OFFICIAL NOTIFICATION OF DECISION

FILE: **Project # 1002176**
 04EPC-00161 EPC Site Development Plan-
 Building Permit
 04EPC-00162 EPC Site Development Plan-
 Subdivision
 04EPC-00163 Zone Map Amendment

LEGAL DESCRIPTION: for all or a portion of Tracts E-1, **North Four Hills**, zoned C-1 to SU-1 Single Family Residential, located on SE QUAD OF FOUR HILLS ROAD SE, between CENTRAL AVE. SE and WATERFALL Drive SE, containing approximately 7 acres. (L-23)
 Deborah Stover, Staff Planner

**C1**

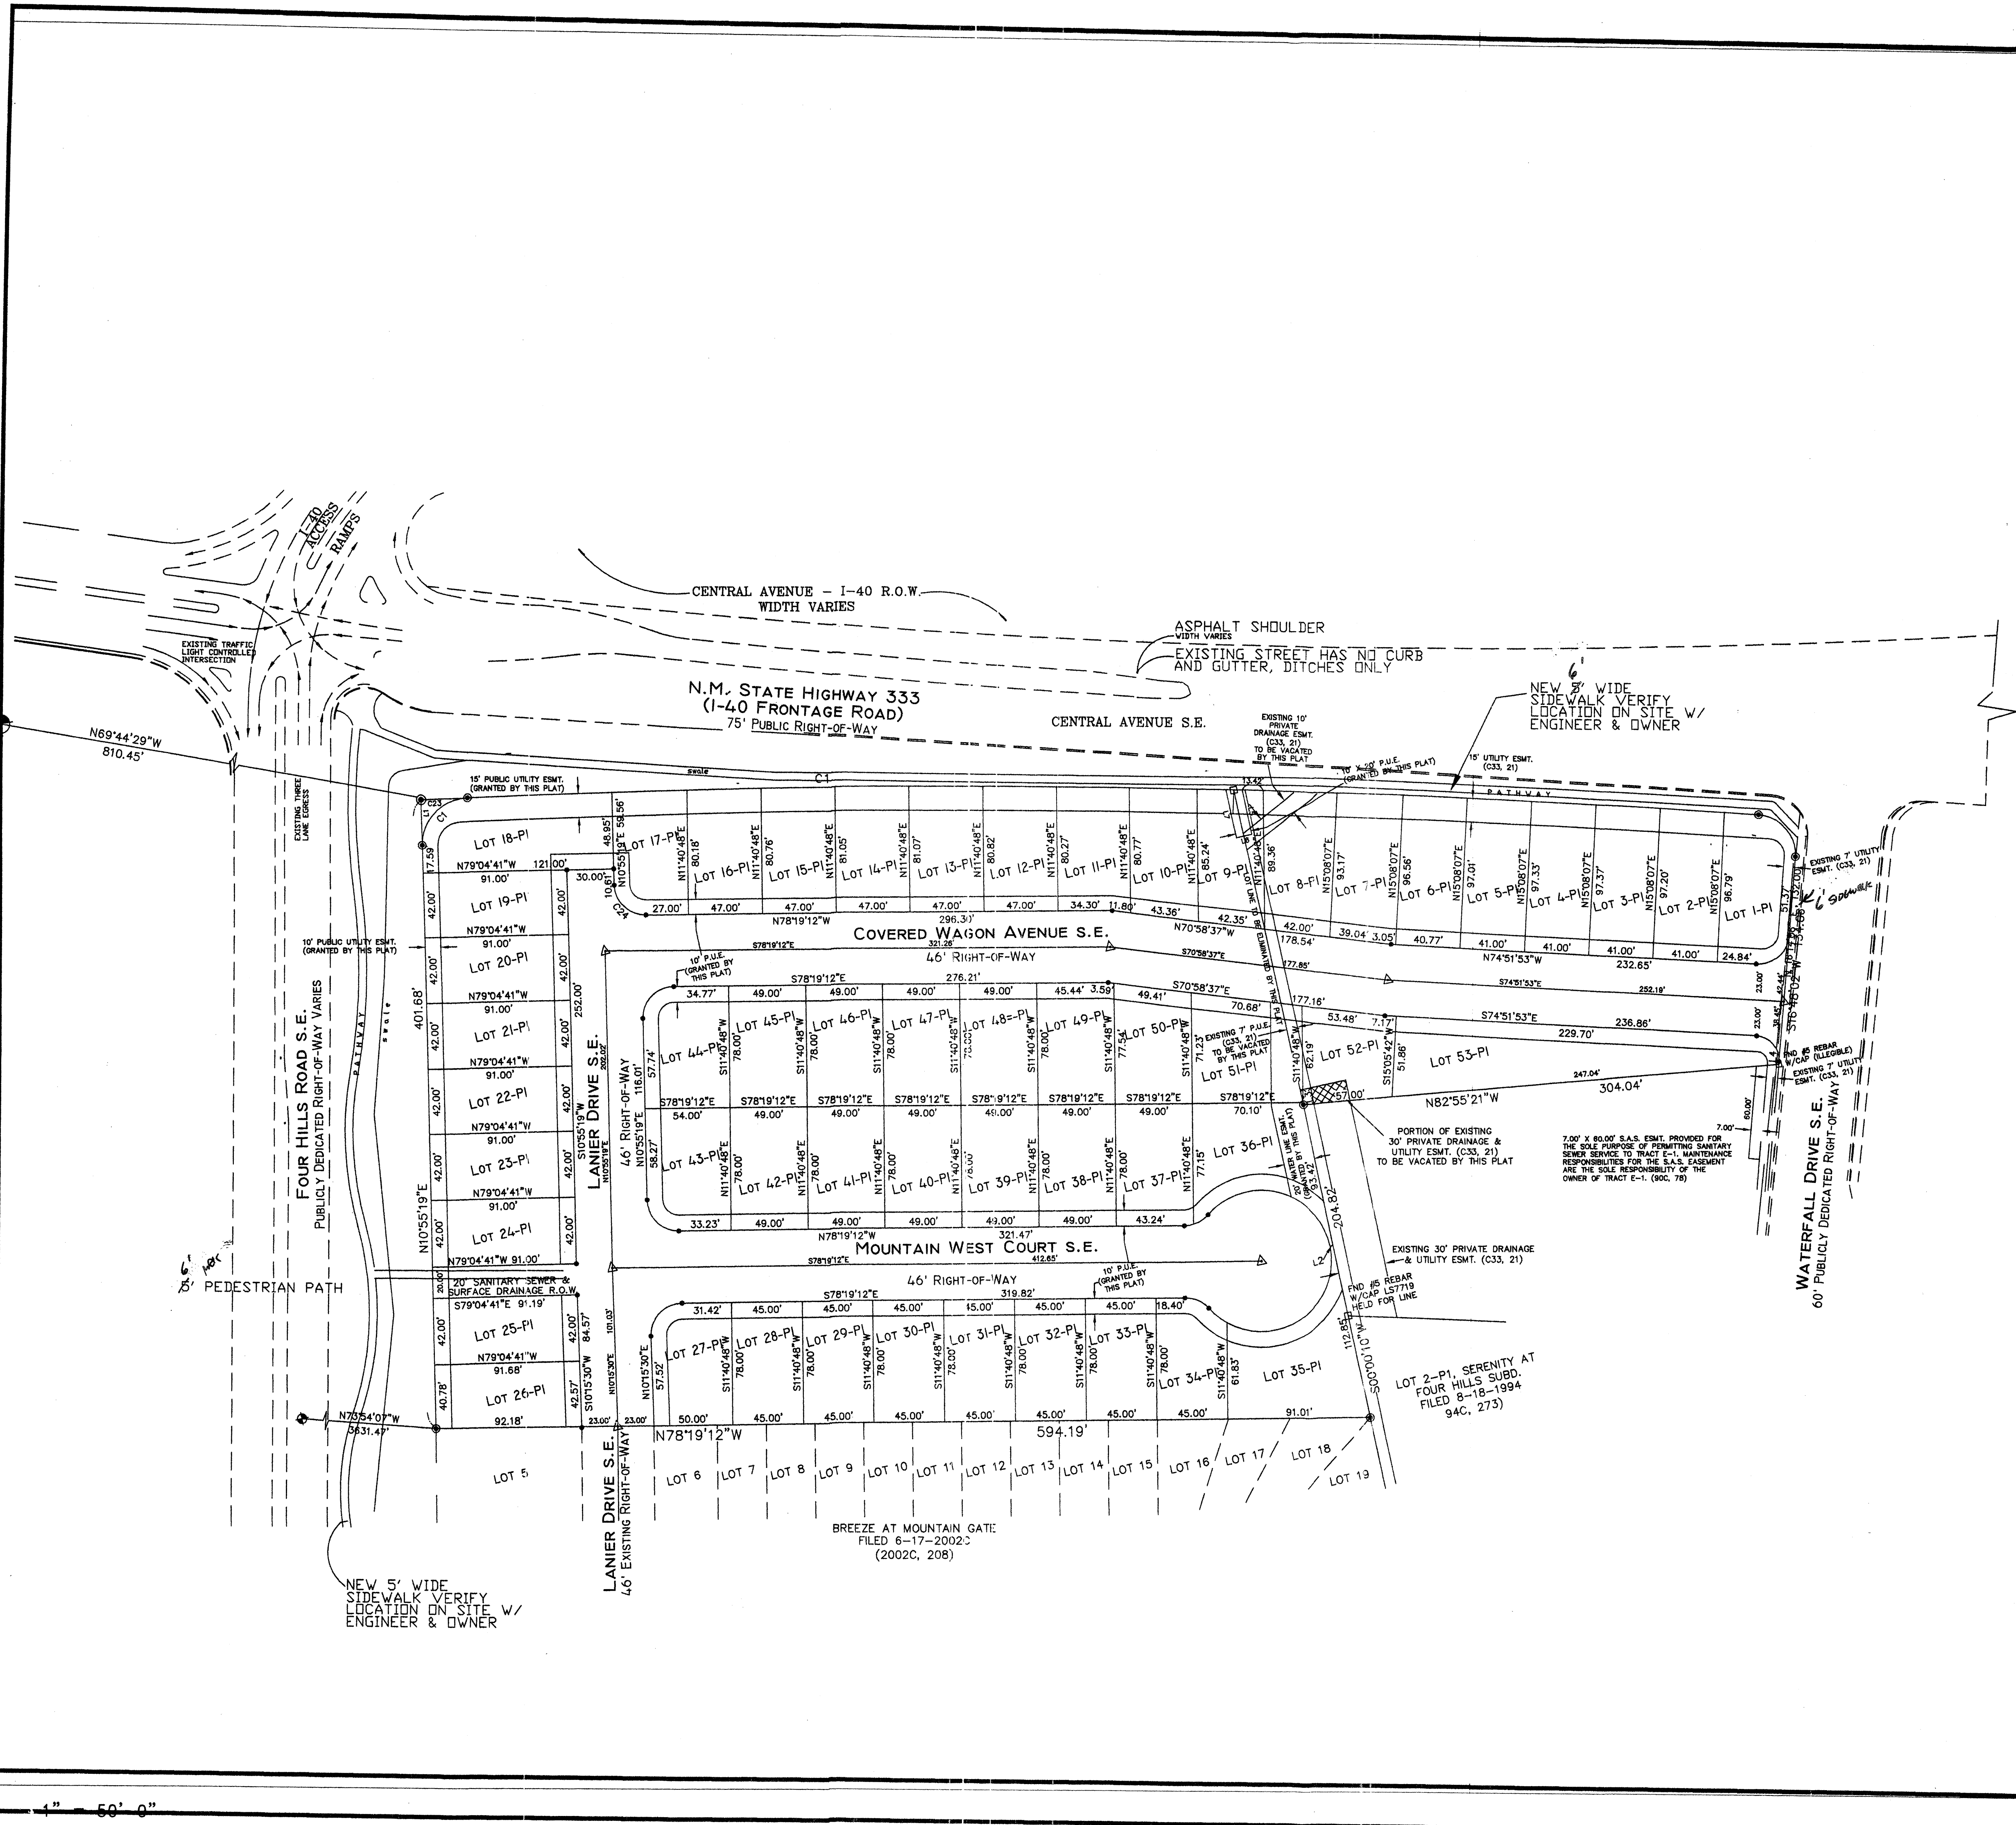
2. Waterfall Drive shall be shown and listed on the site plan, along with the ROW width, sidewalk width, curb and gutter and other appropriate details.

3. The 5-foot wide concrete pathway shall be shown in both locations (along Four Hills Road and Central Avenue) on all site plans related to this proposal.

4. A 5-foot wide concrete pedestrian path shall be provided through this area to clearly connect with the pathway along Four Hills Road.
